WEST SUSSEX COUNTY COUNCIL CONSULTATION

TO:	Arun District Council FAO: James Cross
FROM:	WSCC - Highways Authority
DATE:	26 February 2020
LOCATION:	65 Upper Bognor Road (Charlotte House 71 & 71A Upper Bognor Road, 67 & 69 Upper Bognor Road Bognor Regis PO21 1HR
SUBJECT:	BR/351/19/PL Erection of 2 No. live-work units; change of use of existing student accommodation including internal alterations to form 2 No. dwellings, 2 No. new windows, new staircase & replacement of roof on outbuilding; reconfiguration of existing dwellings, replace existing timbers & roof joists on first floor; change of use from medical centre/offices to 2 No. flats & workshop. creation of new private gardens, separation of this part of the site from the wider University campus, creation of a shared landscaped courtyard, creation of areas for parking & storage for bins & cycles. This application affects the character & appearance of the Upper Bognor Road & Mead Lane Conservation Area.

University of Chichester
Upper Bognor Road Residential Redevelopment
Drawing
Site Plan As Existing

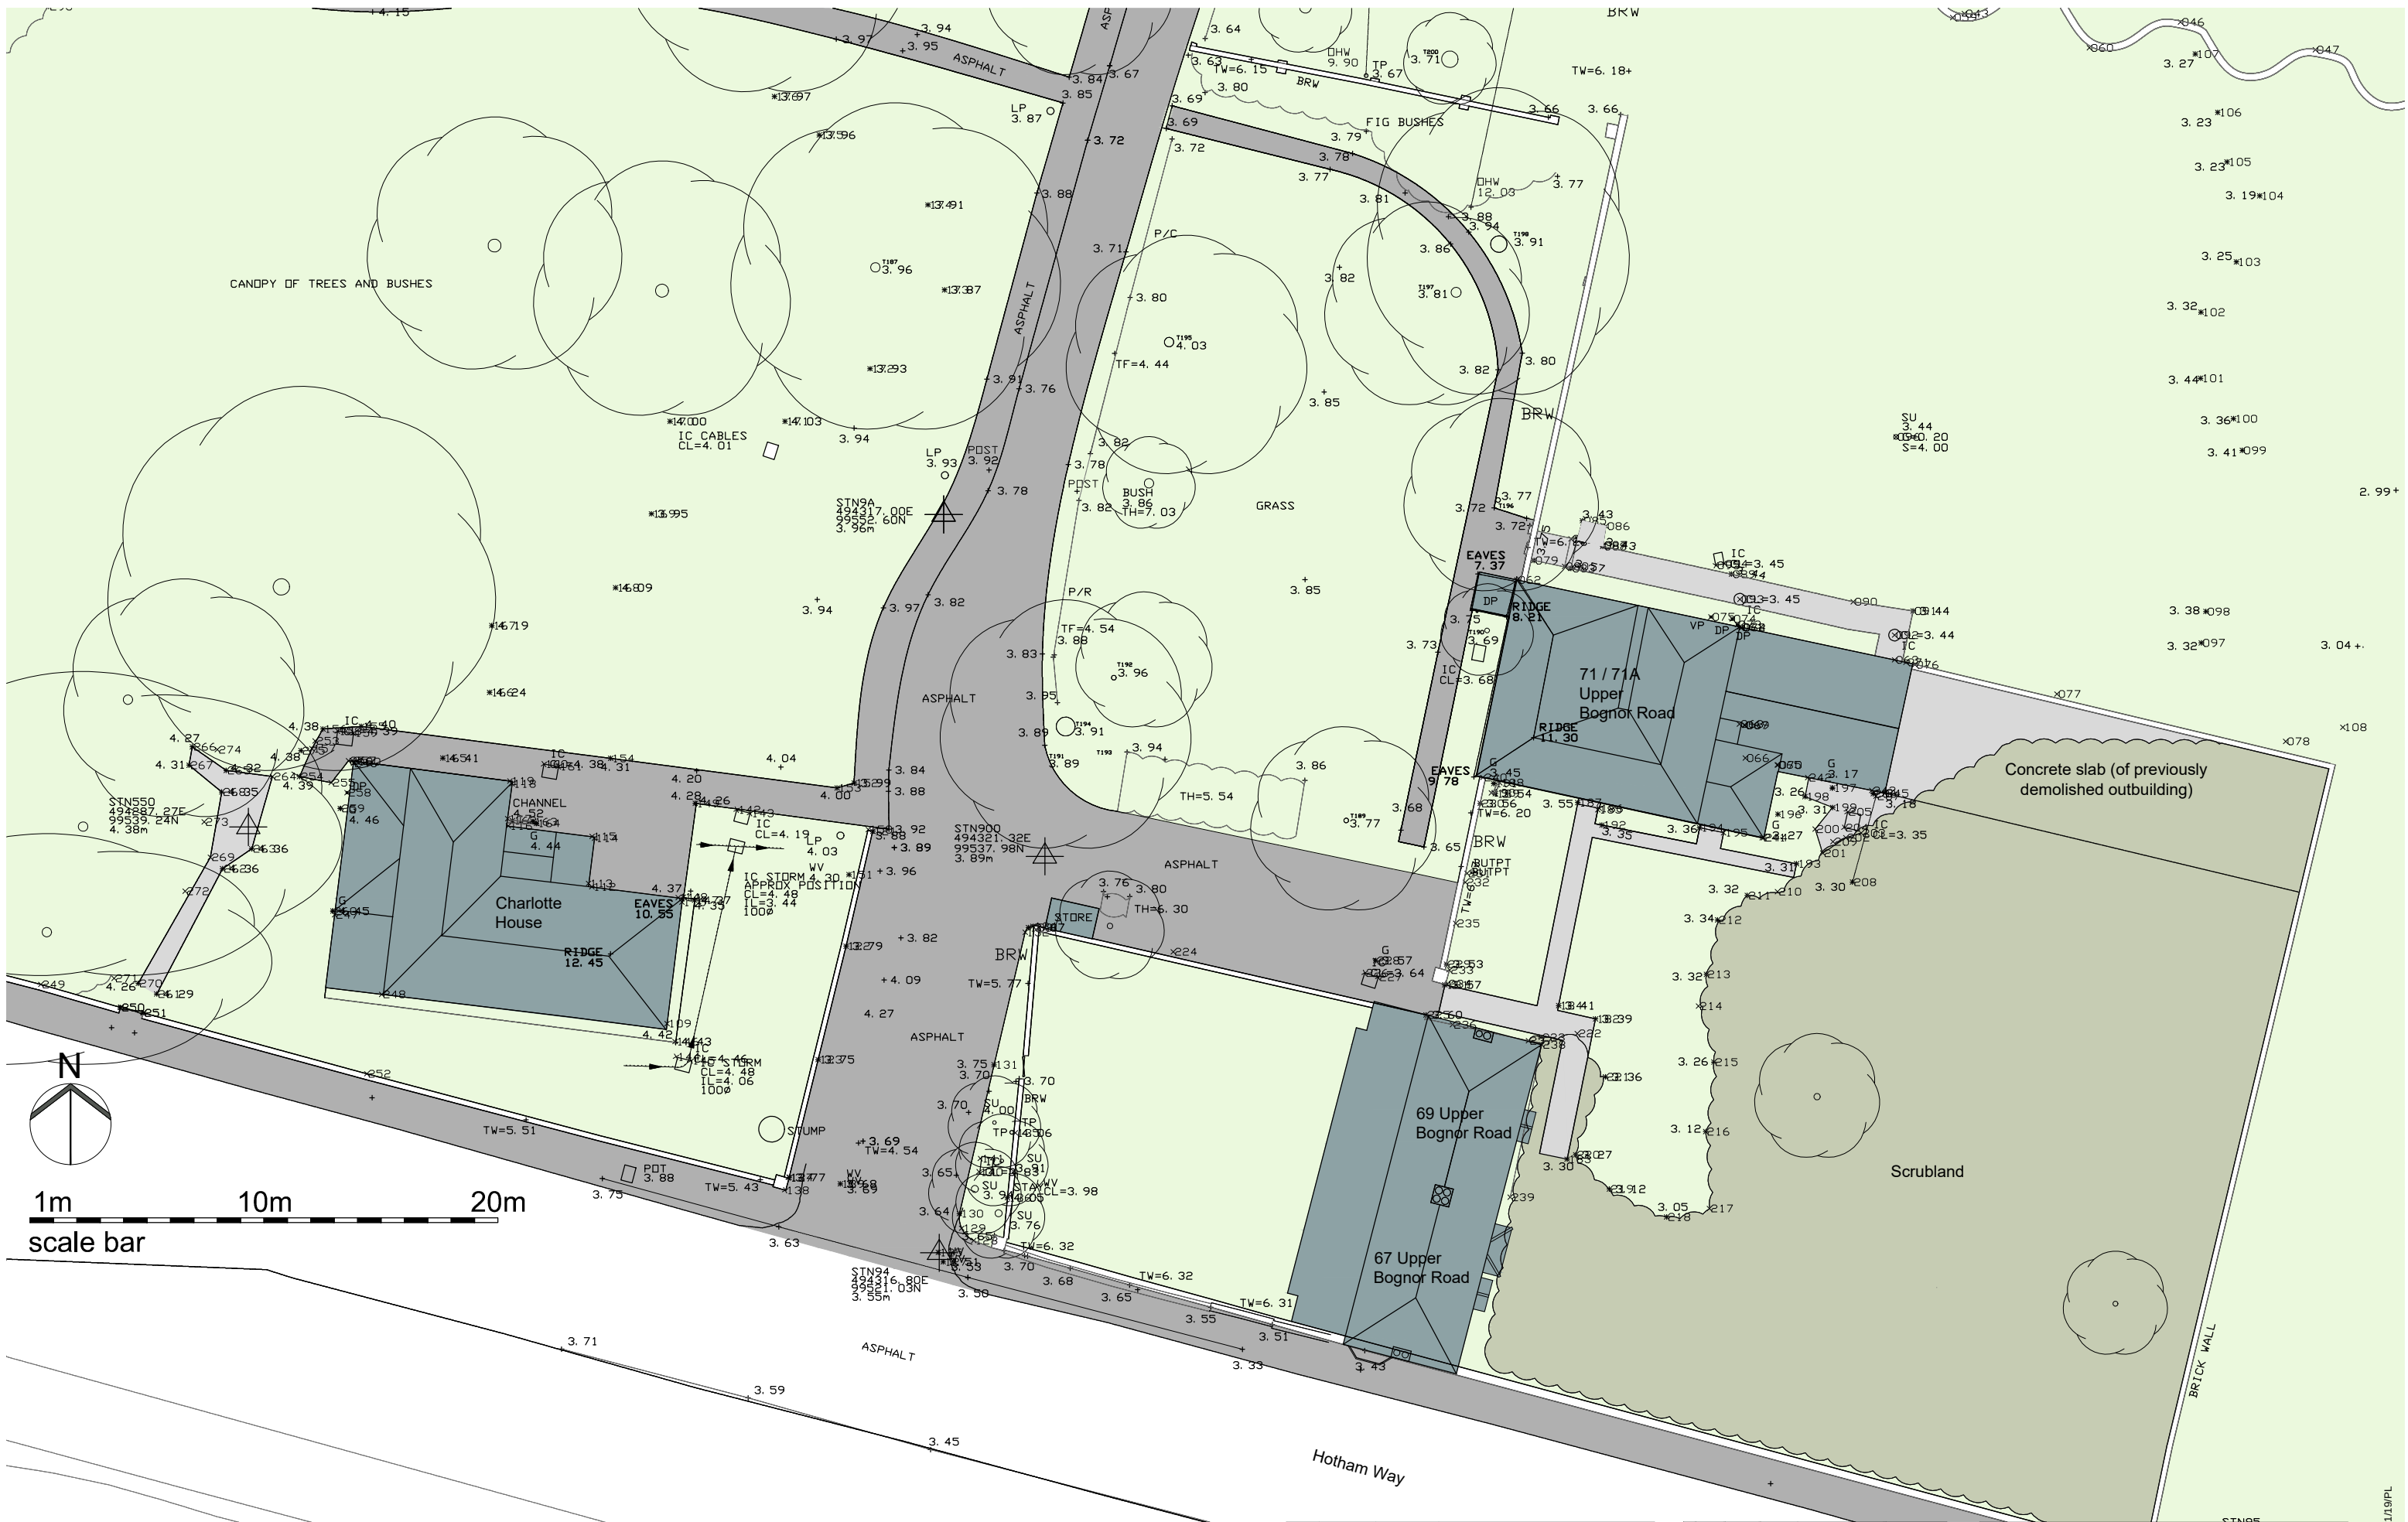
It is clear from the plans that the access serves the university campus and leads to a car park a short distance north of the application site.

The LHA is mindful that with the implementation of BR/54/16 an internal north -> south one way link road has been created so vehicles in this car park could potentially exit the site via the higher specification priority junction located on Felpham Way. There do not seem to be any planning controls in place to enforce this, so potentially these vehicles could leave the site using the existing point of access subject of this application.

Given this internal link road is one way the applicant should clarify the intended future operation of the car park north of the application site. As proposed, it seems this car park would no longer be accessible.

Without clarification on this matter the LHA are not able to make any assessment over a potential intensification of use of the existing access point. The applicant should also clarify what types of vehicles are currently using this point of access, refuse and servicing vehicles for example.

Visibility splays have not been provided alongside this most recent application, the Local Highways Authority (LHA) therefore advise that the applicant provides maximum achievable visibility splays as per WSCC and Manual for Streets (MfS). All Visibility splays must include a 2.4m setback distance from the kerb edge of the footway and span in both directions to the kerbed edge. The splays must not intersect third party land, be located solely within land under the control of the applicant or within the Publicly Maintained Highway, and include the current road geometry. We have provided a diagram below for your guidance only.

Given the change to the internal layout, the LHA requests the applicant provide swept path tracking to demonstrate that all vehicles have the ability to turn within the site and access the publicly maintained highway in a forward gear.

- Swept Path tracking as shown on the site plan as detailed in Turning above,
- Maximum achievable visibility splays at the access point onto Upper Bognor Road as details above,
- Anticipate trips of both existing and proposed as detailed above / clarification of the operational use of the car park north of the application site.
